21<sup>st</sup> February 2020

***Re: Response to Agency Comments on SSD5300 Mod2 - Kembla Grange Resource Recovery Facility***

**Table 1. Agency comments, and subsequent responses and actions are provided in Table 1 below.**

Project No. KF110816	Sheet 6 Of 20
Drawing No. C305	Revision E

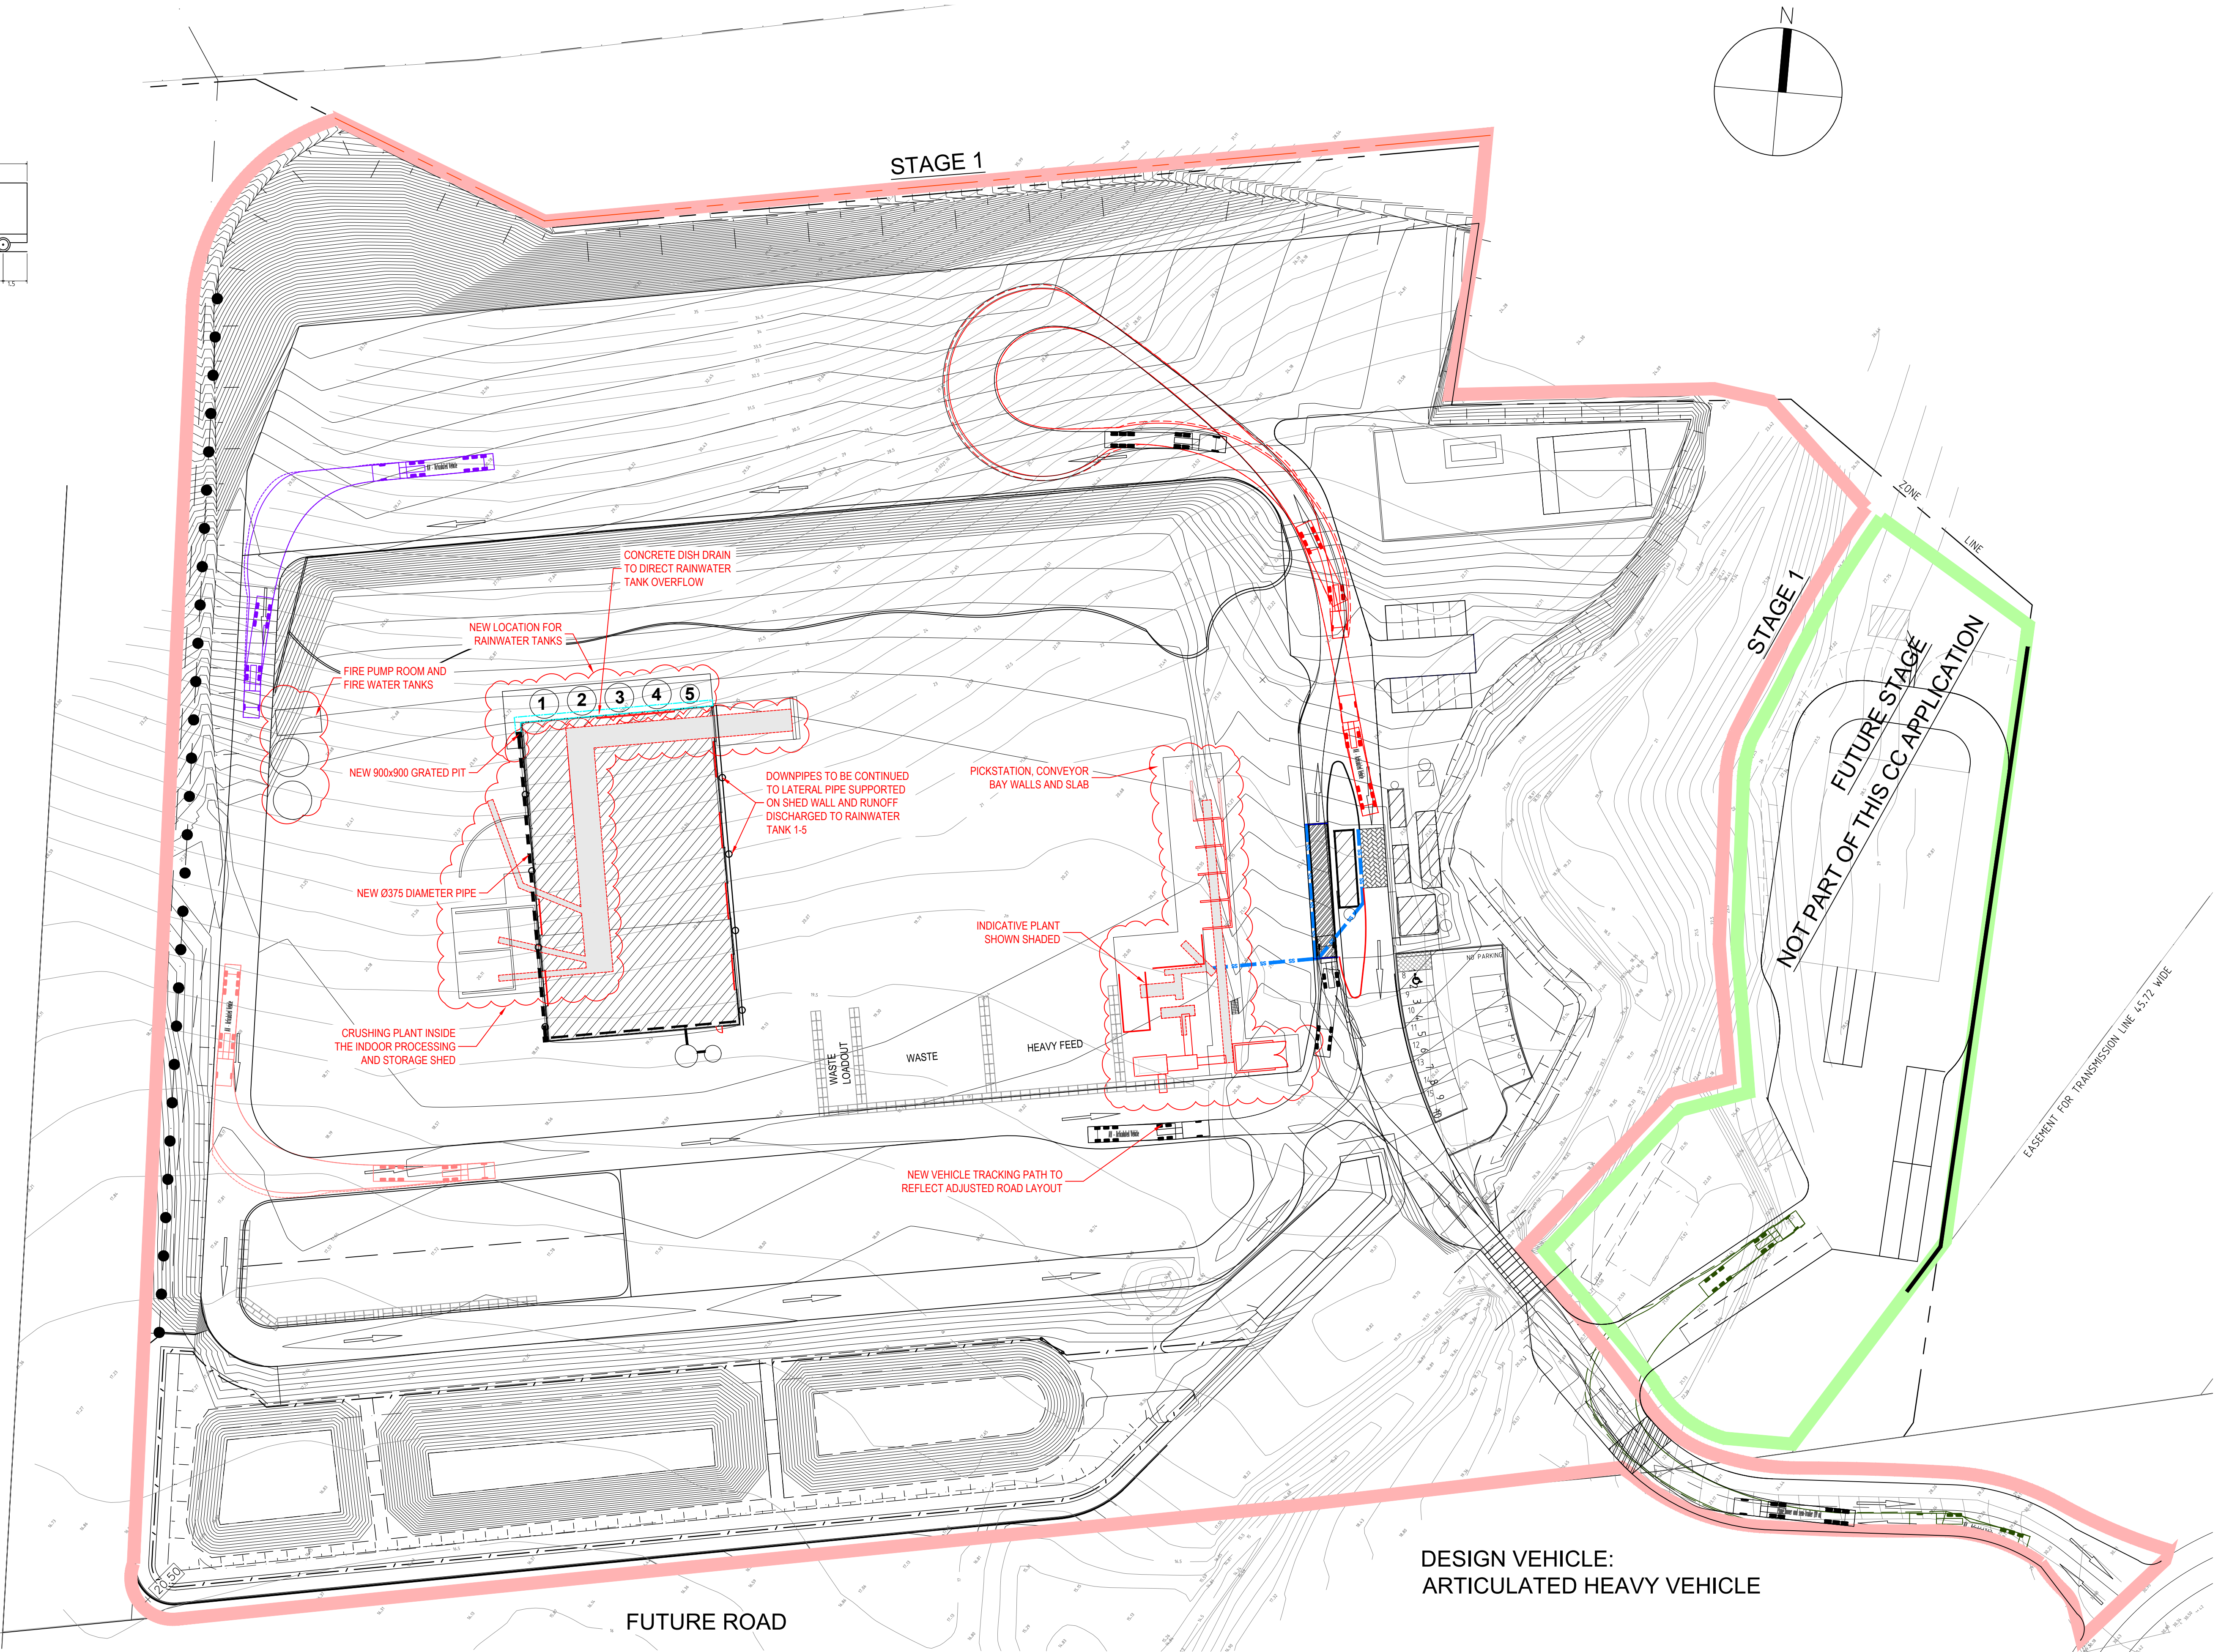
Wollongong City Council	The 'Blown Material Cage' appears to interact with the turning movements and site access arrangement for the site. The turn path provided on Drawing C305 Job no. KFI 10816, Revision D, dated 09/10/2018 utilises a Heavy Rigid Vehicle at the location adjacent to the 'Blown Material Cage' when the design vehicle for the rest of the site is an Articulated Vehicle.	Noted.	The new vehicle tracking path to has been updated to reflect the adjusted road layout and shows no interaction with the Blown Material Cage. The swept path plan has been updated and is included in Appendix 3a of the Statement of Environmental Effects (see Plan C18)
Department of Planning and Environment	<p><b>Outdoor pick station</b></p> <p>The Statement of Environmental Effects (SEE) dated 23 November 2018 does not provide any details on how dust will be managed within the “fully enclosed outdoor picking station” Please provide details regarding the current and proposed dust management and mitigation procedures from within the “fully enclosed outdoor picking station”?</p>	The Applicant accepts this proposed condition	<p>Section 2.6.3.2 of the Statement of Environmental Effects has been updated noting dust management, including mitigation measures to maintain dust levels as approved in the OEMP.</p> <p>It is noted that no ambient dust is created by the picking station as it is effectively an enclosed conveyor. Waste</p>
